RE: Letter of Objection for planning application 3/2021/0660

I am contact you with regards to the planning application number 3/2021/0660, Grid reference: 369068 450229.

We have been in contact with United Utilities following the proposed works for the Bowland section of the Haweswater Aqueduct Resilience Project, which I believe will have significant implications on our residential dwelling, the local environment and economy, and the health and welfare of those in the area.

SCALE 1:10,000	SHEET SIZE A3
DRAWING NUMBER LCC_RVBC-BO-FIG-003-001A	REVISION 0

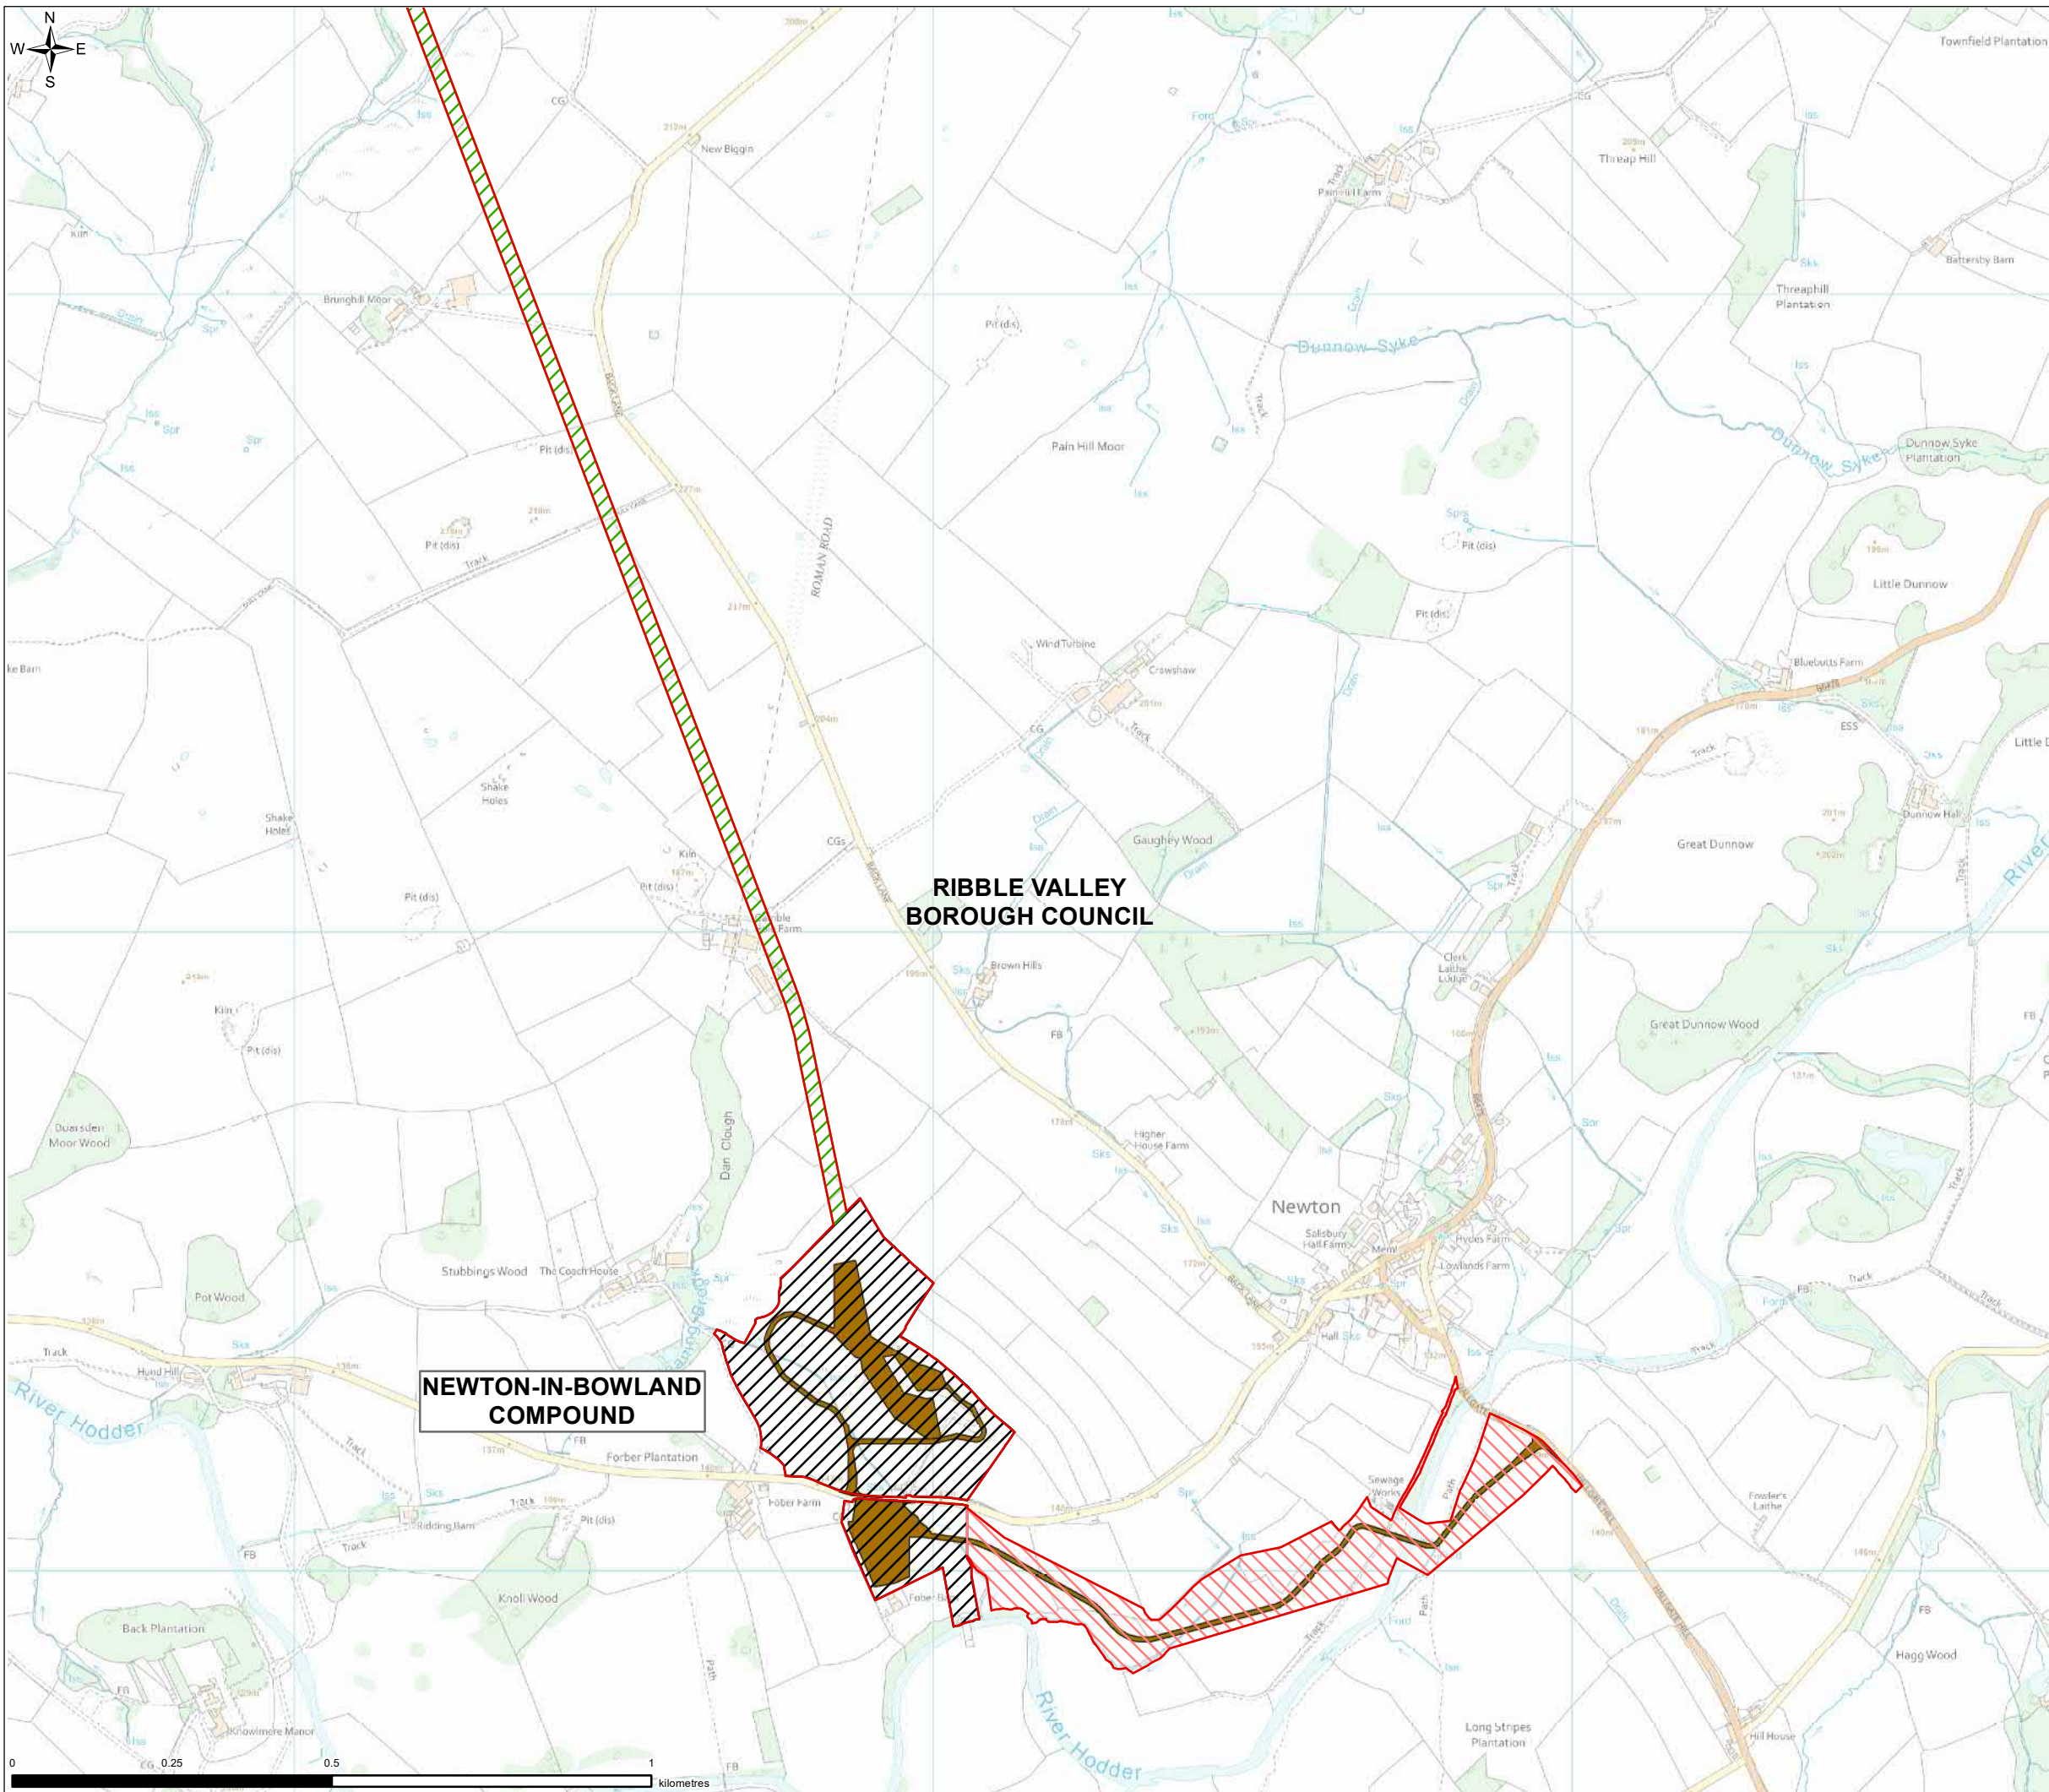
The estimated 24m buffer strip, which is the estimated boring path has moved since the original proposal United Utilities approached us with in 2019. At this stage, preliminary ground works in the form of geophysical vibriosis monitoring was done in order to estimate the ground composition prior to works. The original path and plan followed Backlane and went right by This plan has however changed in the new proposal and as such, in the planning application.

From the map below, the new bore route is closer which raises concerns with regards to building subsidence. United Utilities have stated that this is "Unlikely" but as they do not know what sort of terrain they are entering, anything is possible. If they hit rock, the vibrations alone even 100m down have the potential to cause on ground issues with building foundations. What happens if subsidence occurs when the Although this is an upsetting thought, our main concern with the works is our water supply.

I am afraid that the new pipeline plan is dangerously close to [REDACTED]. As stated previously, the original plans we were sent followed the roadside, but this map indicates that the tunnelling will be [REDACTED]. Therefore, these plans will more than likely enter our water aquifer, which the water table sits approximately from 90ft to 285ft deep, with a 110ft sleeve.

MSSD763 - Newton-in-Bowland
 Figure 2 - Location of Survey Areas
 1:5,000 @ A3
 Copyright Magnitude Surveys Ltd 2020
 Contains Ordnance Survey data © Crown Copyright and database right 2020

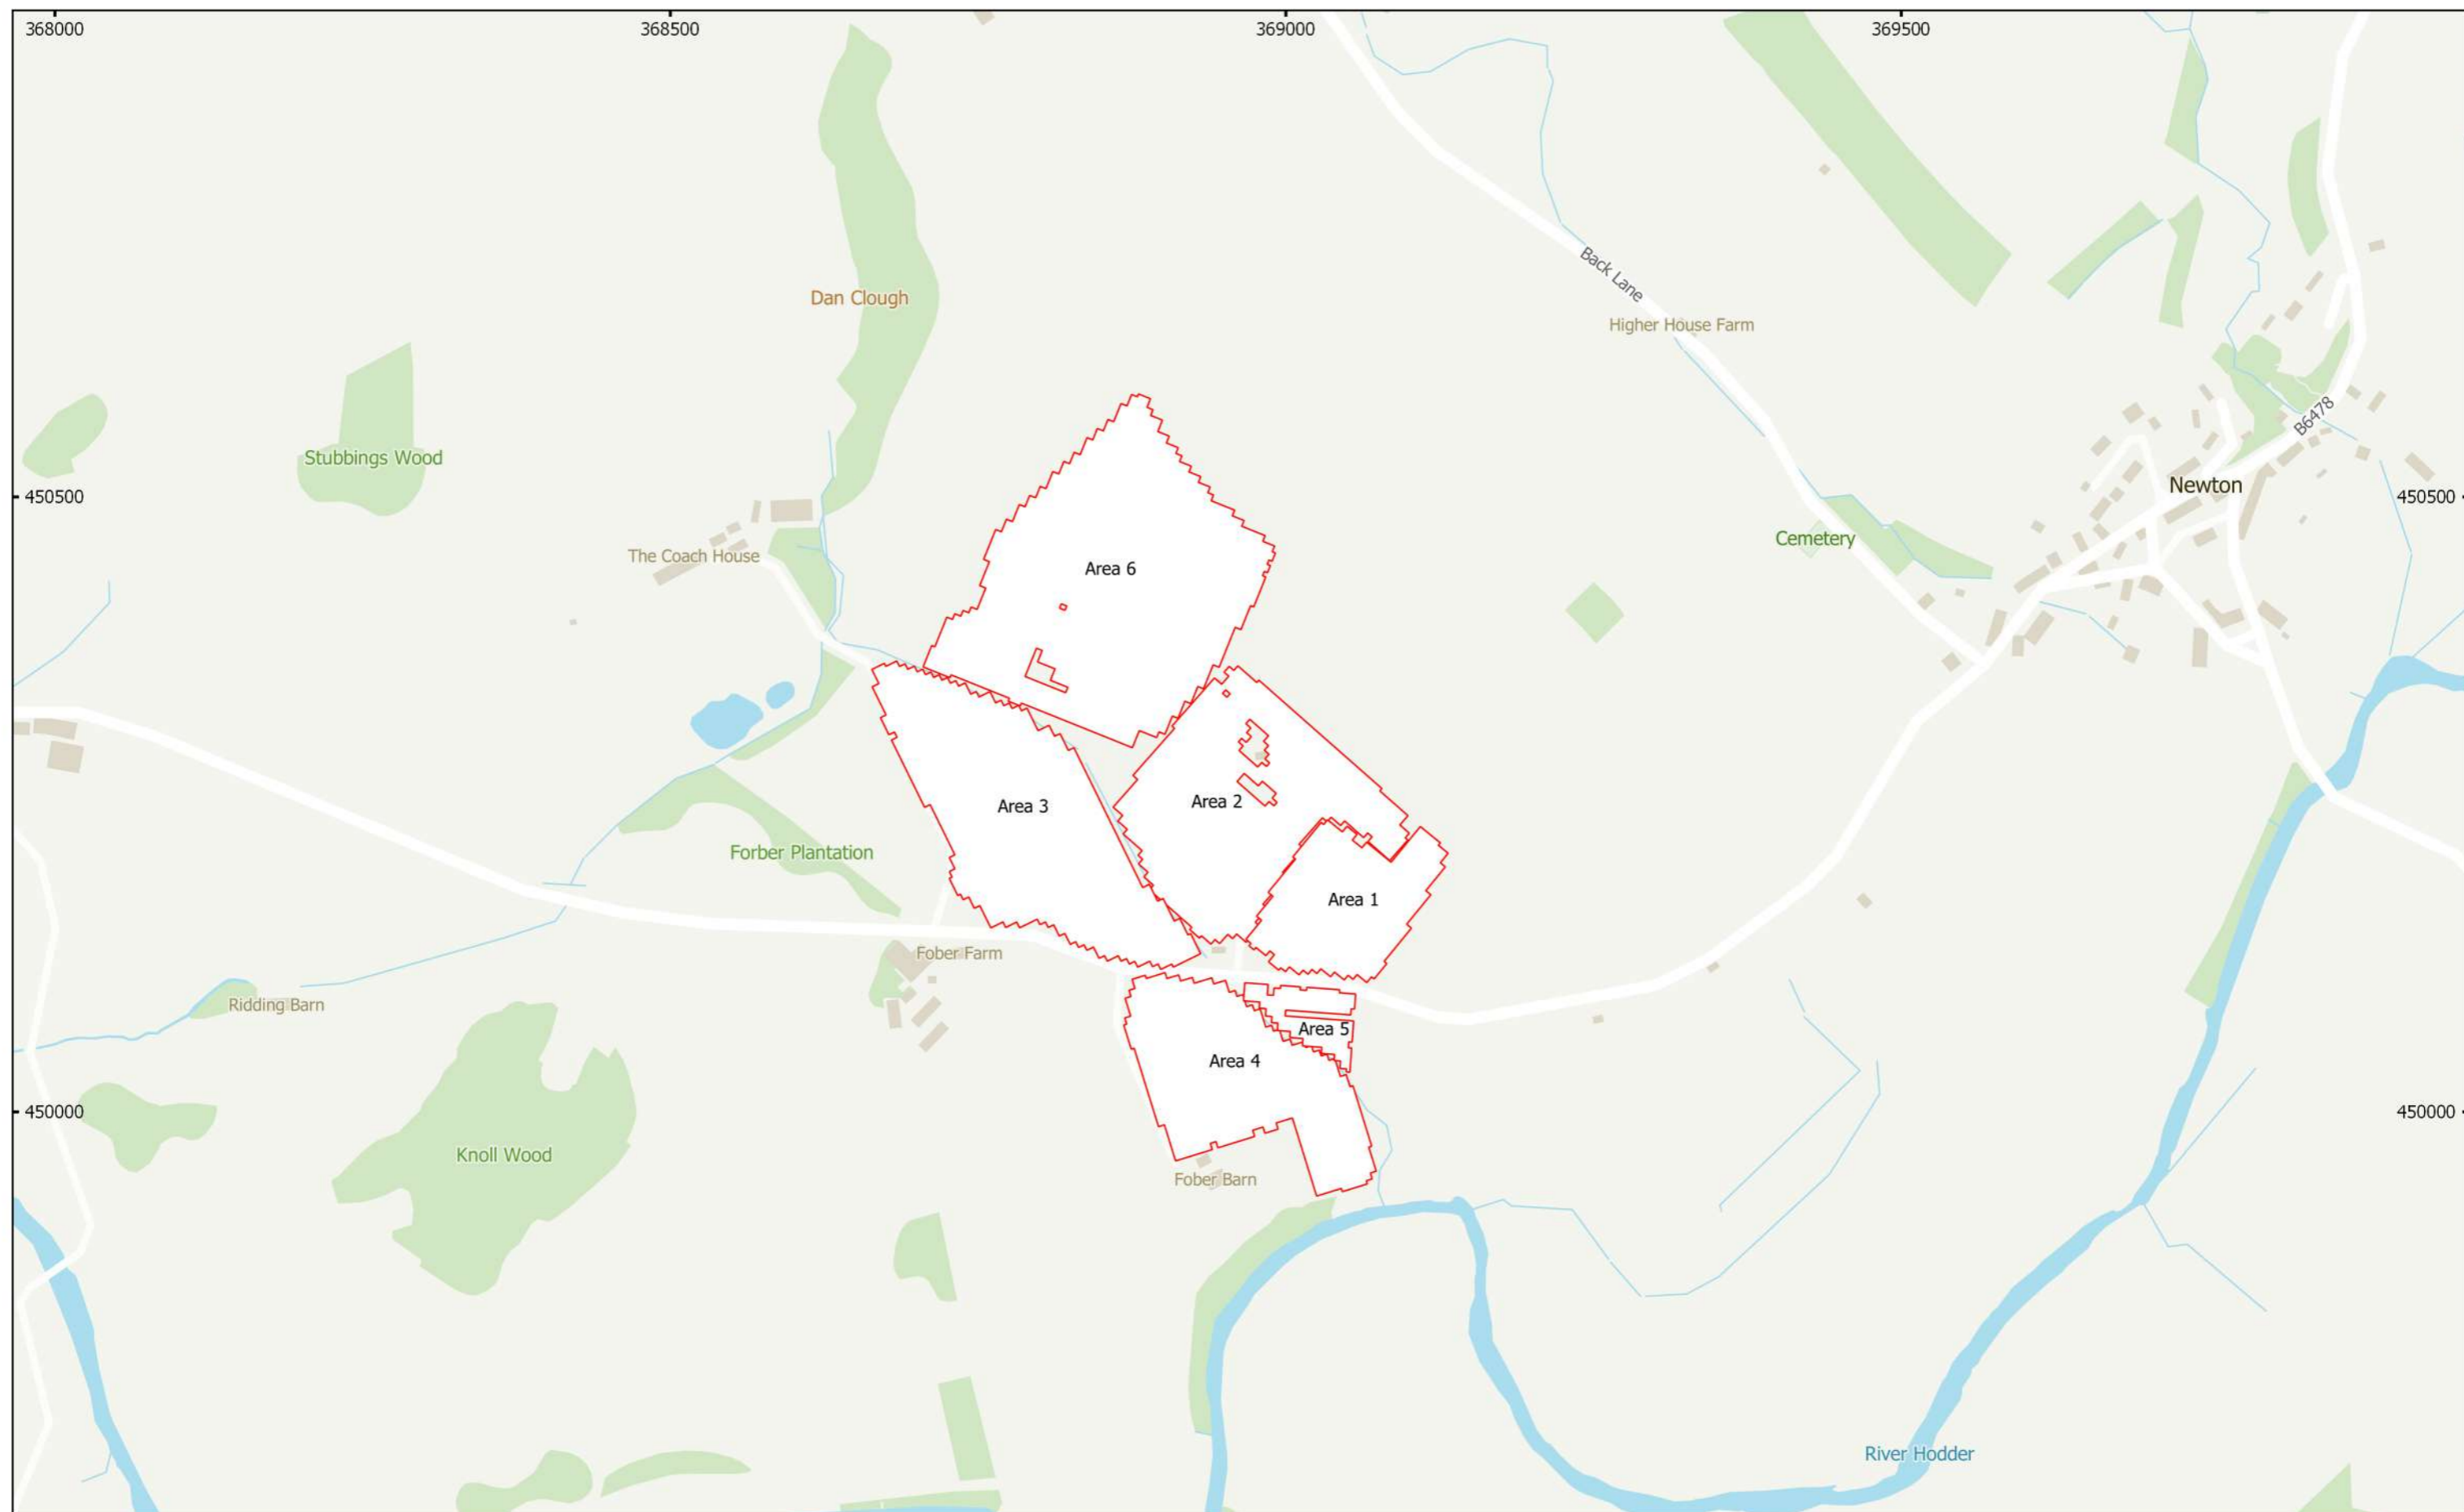
It is concerning that the preliminary geophysical surveying that took place to determine the land profile will not be a true guideline for the actual ground they will be entering, as the vibriosis machine followed the road, again, which is where United Utilities stated the tunnel would be going. As the entry point for the tunnel is less than 2000m away from the farm, the depth the borer will be when it reaches this point has the potential to compromise our water source. Being in a rural place, we do not have the option to go onto mains water.
